Our reference: EF13/3921: DOC15/11474-01
Contact: Andrew Helms (02) 6332 7604

Environment Impact Statement – Borg Panels, Oberon – DA 27/95 (Mod 7)

Attachment 1: EPA comments and recommended conditions of project approval

Site Plan

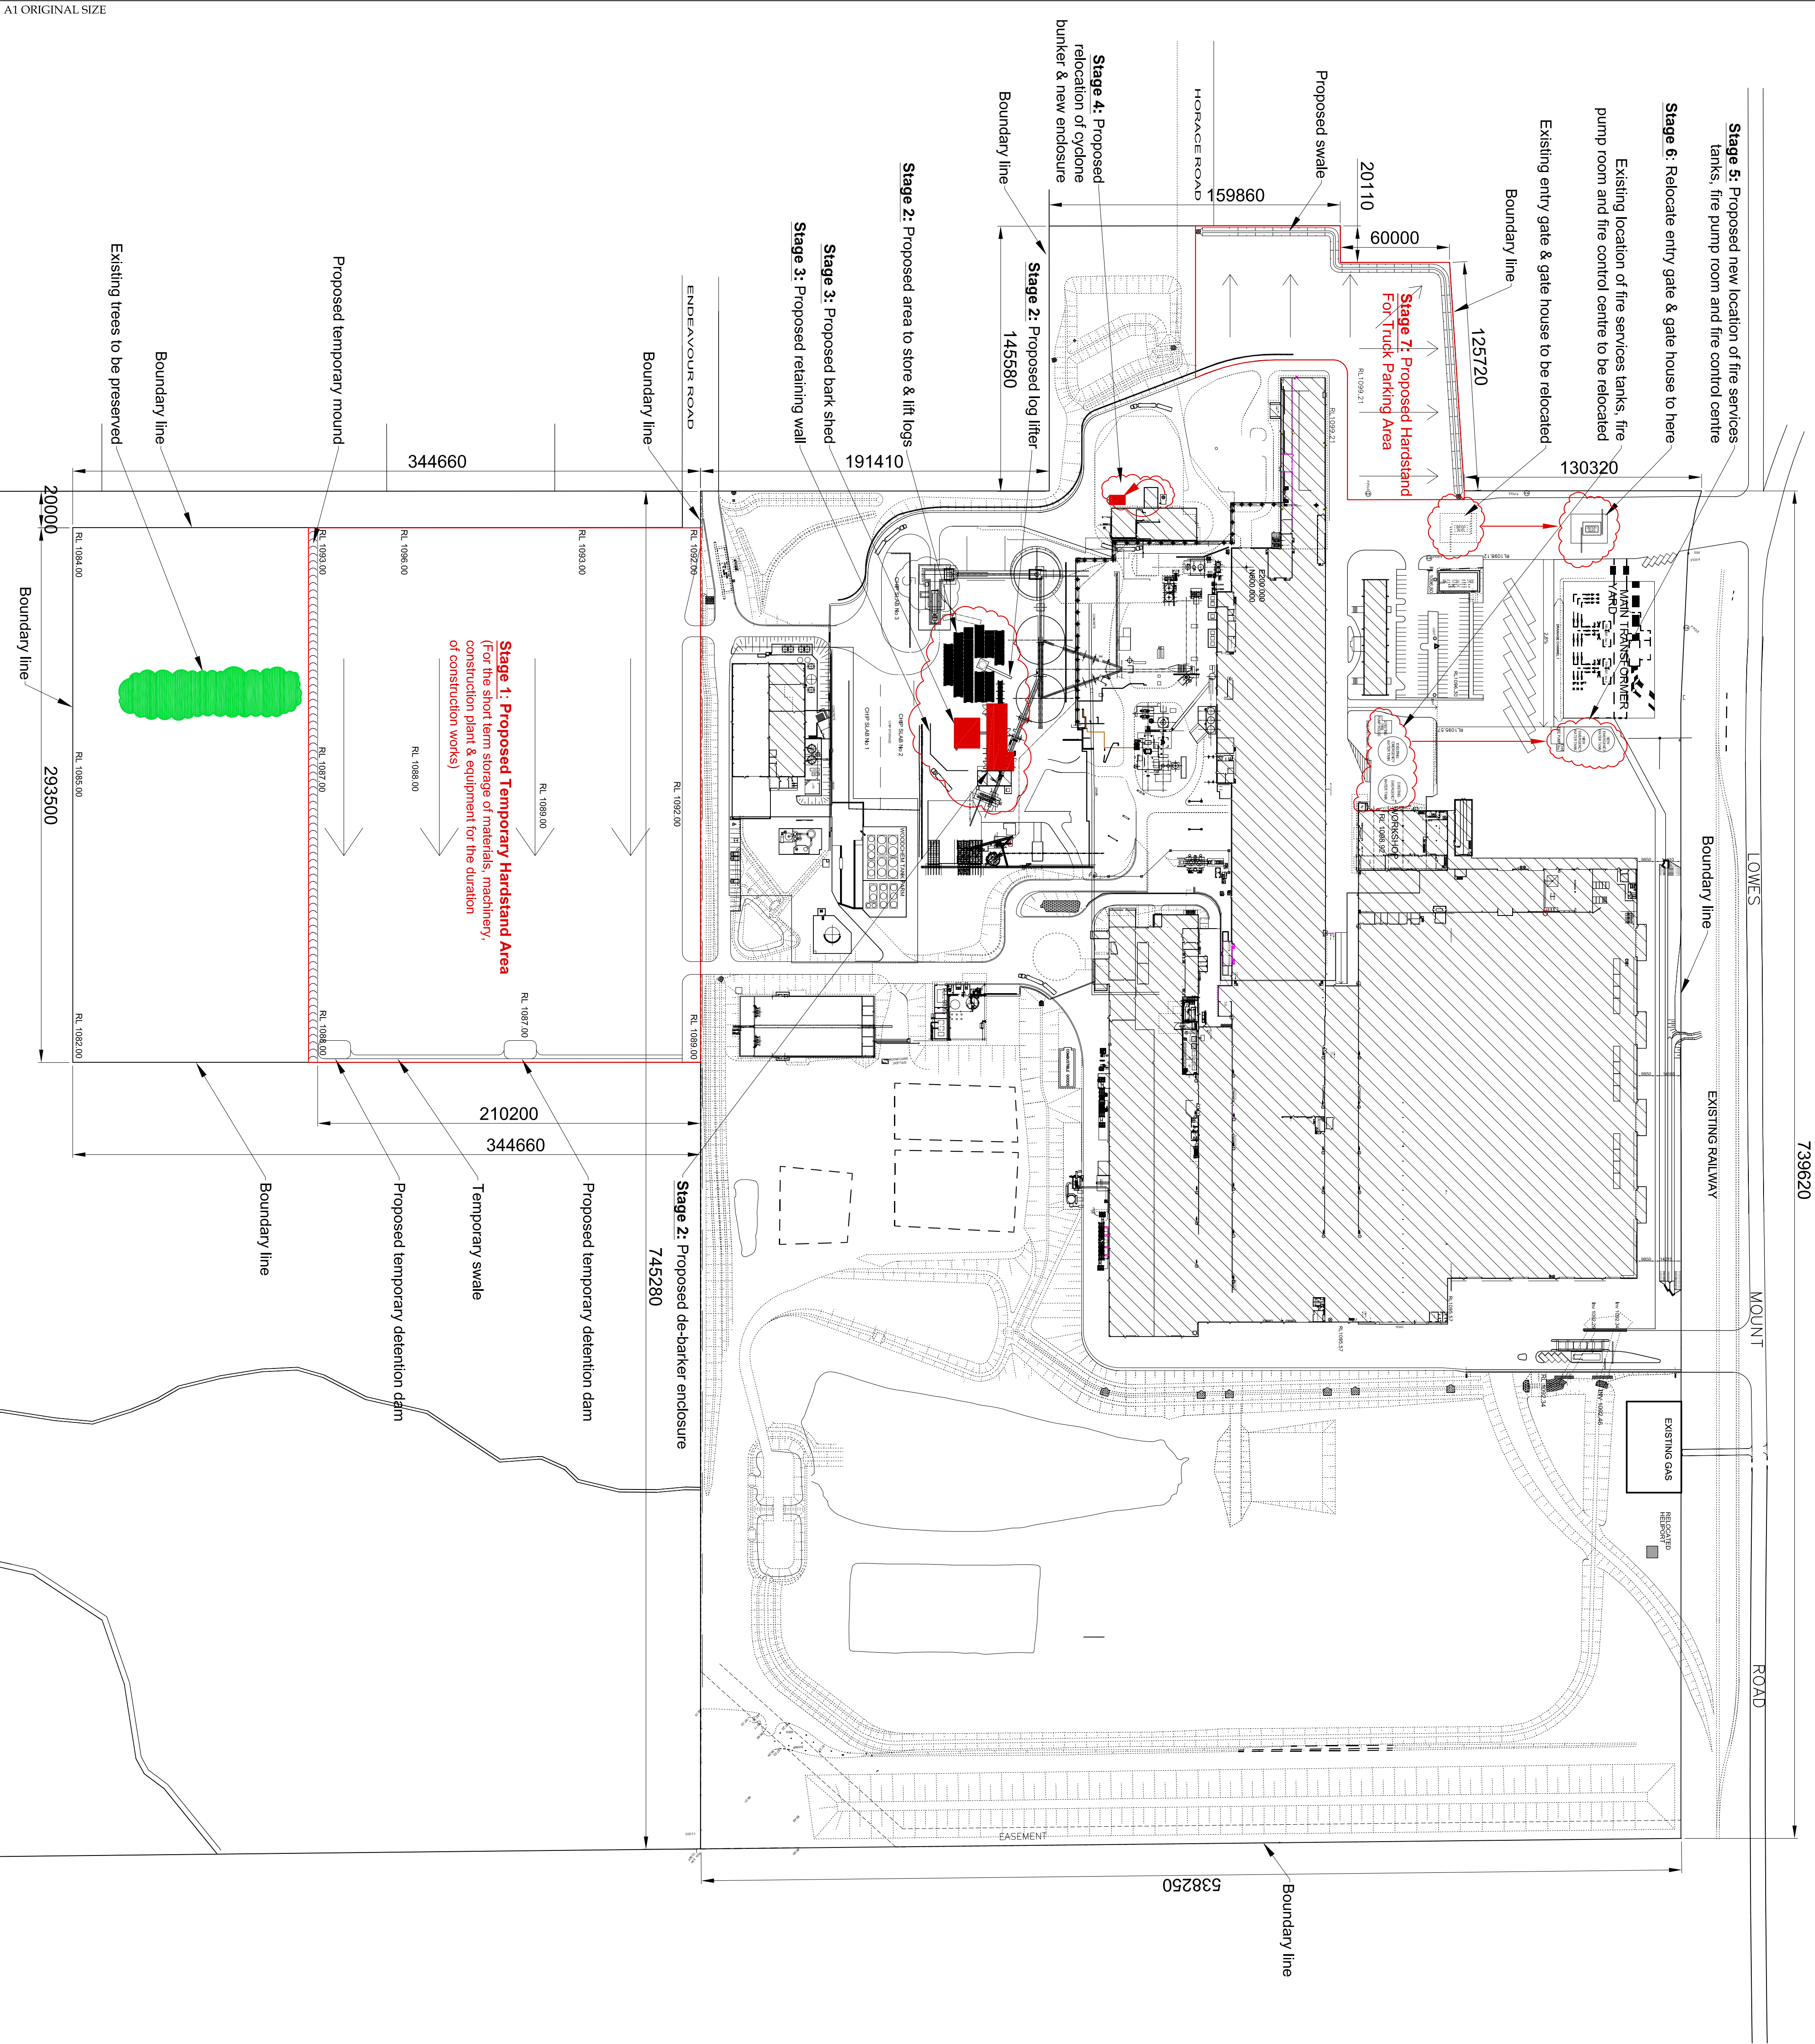
The EPA notes that the proposed modifications to the operations at the Borg Panels facility are likely to provide an overall improvement in air quality with the enclosure of several potentially dust generating operations and the concrete paving of a truck parking area in the south-west corner of the facility.

The proposed temporary hardstand area on the vacant block of land to the east of the Borg Panels facility has the potential to generate dust from increased traffic movements during the construction period if not managed appropriately. The EPA is also aware that this vacant block currently has a large stockpile of sawdust generated from within the Borg Panels premises. The stockpile is not enclosed on any sides and therefore exposed to prevailing winds and has the potential to impact upon neighbouring businesses and the Oberon local environment in general.

- The stockpiling of sawdust on the vacant block (identified as Lot 2902 DP1056754) must be in stockpiles not more than three (3) metres in height and enclosed on 3 sides so as to prevent the mobilisation of sawdust by wind, unless the stockpiles are fully covered by a tarpaulin.

- All sediment control structures on the vacant block (identified as Lot 2902 DP1056754) must be constructed in accordance with *Managing urban stormwater: soils and construction*, vol. 1 (Landcom 2004).

De-Barker & Bark Shed Floor Plan

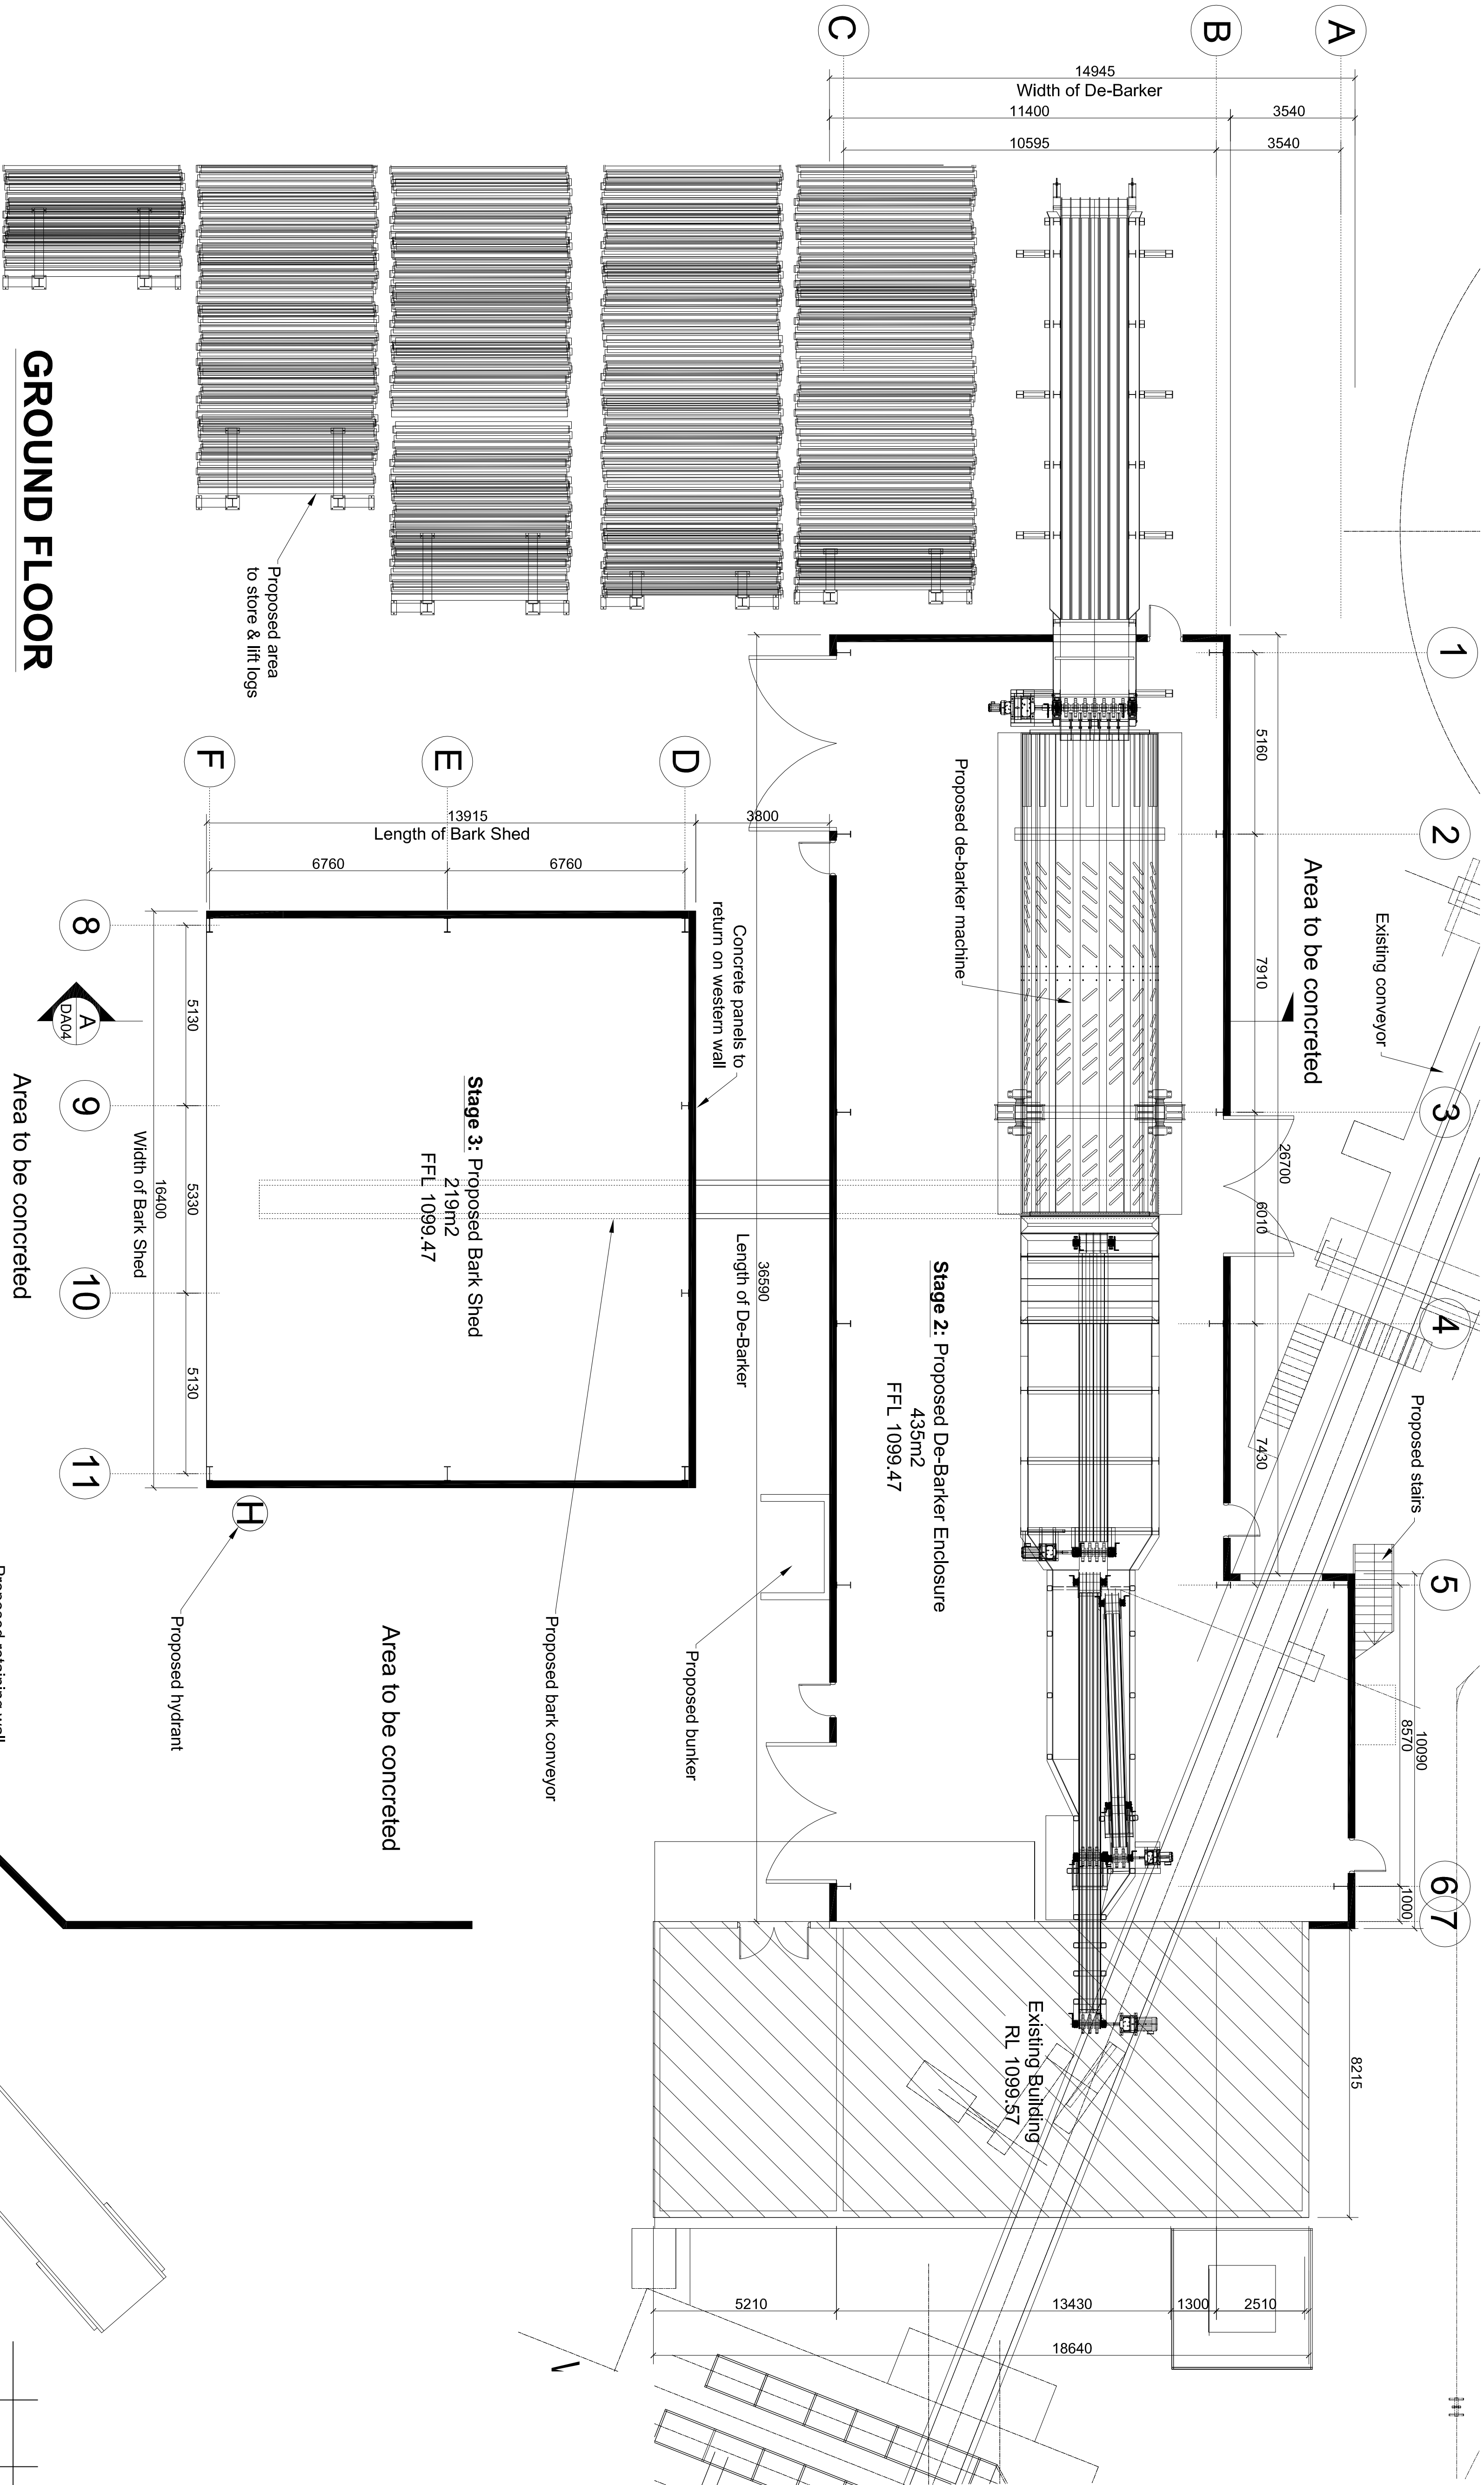
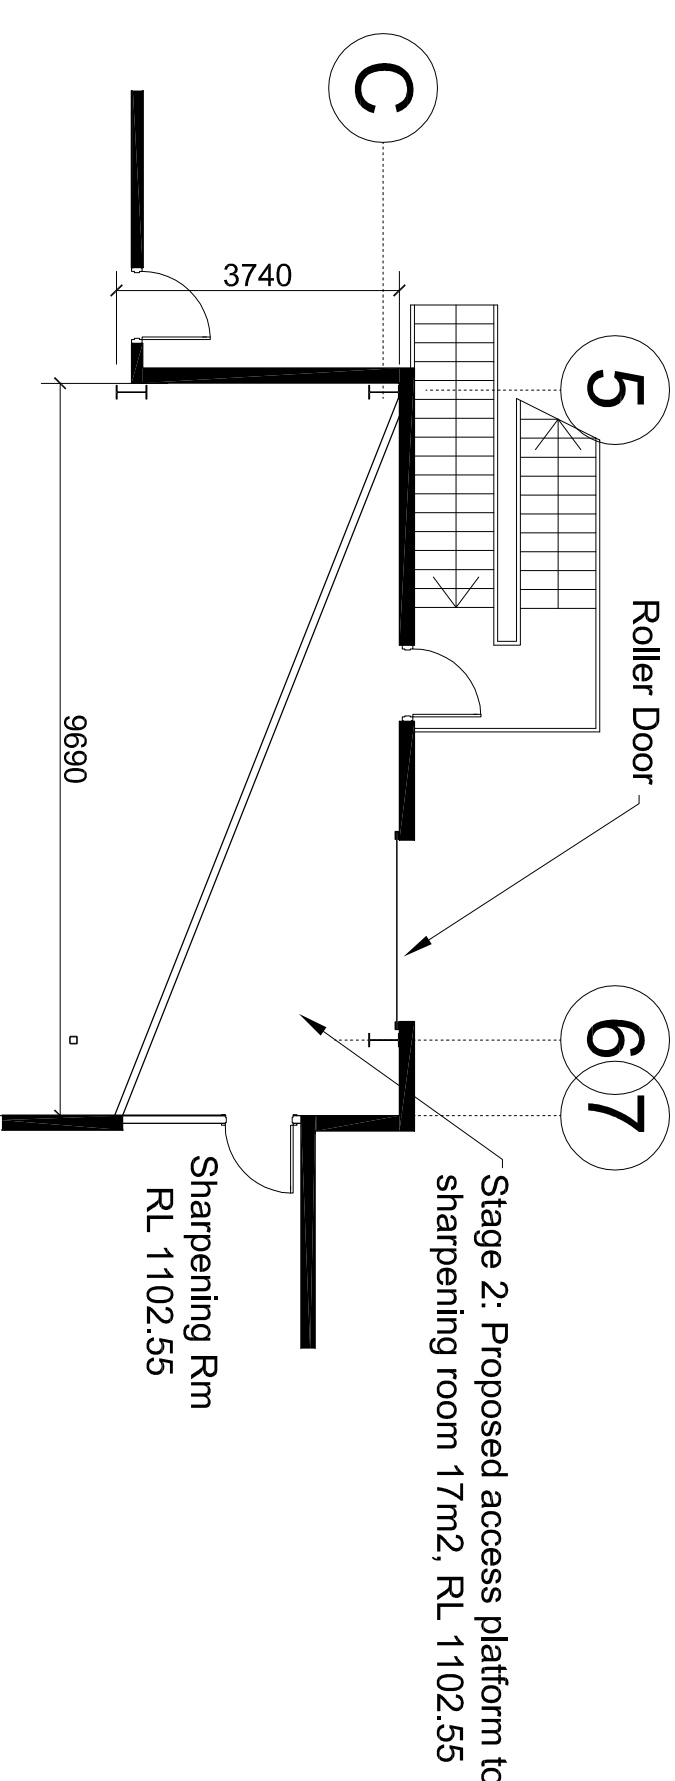
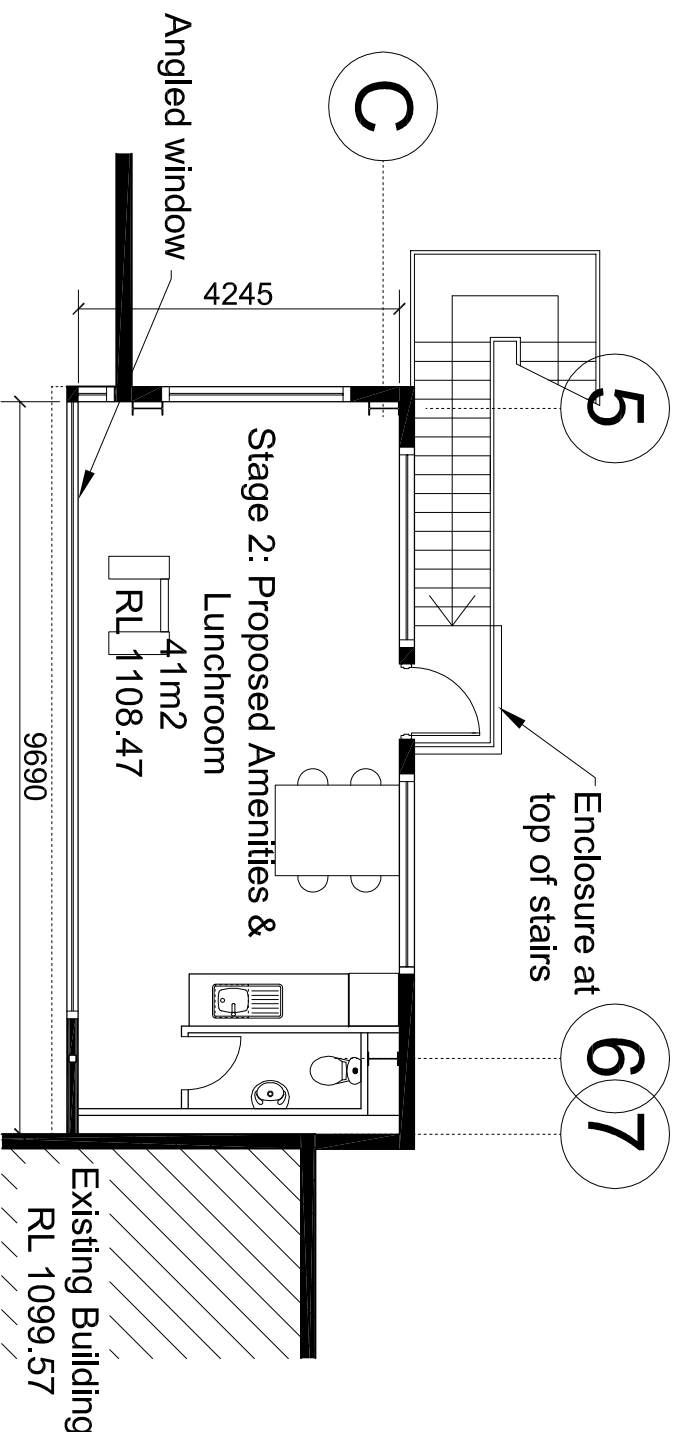
The EPA has reviewed Section 5.3.11 of the EIS and Attachment B (Noise Impact Assessment for the de-barker/shredder plant) and notes that the general noise environment at the premises will be improved following the construction of the de-barker building, bark shed and following the relocation of the cyclone bunker as these facilities will be undertaken within enclosed structures rather than out in the open as is currently the case. The EPA also notes that noise modelling indicates that the enclosed de-barking facility will not be audible at sensitive receivers.

The EPA considers that the existing noise limits on environment protection licence (licence) 3035 are appropriate and therefore that the activities if approved must comply with the existing noise limits under licence 3035.
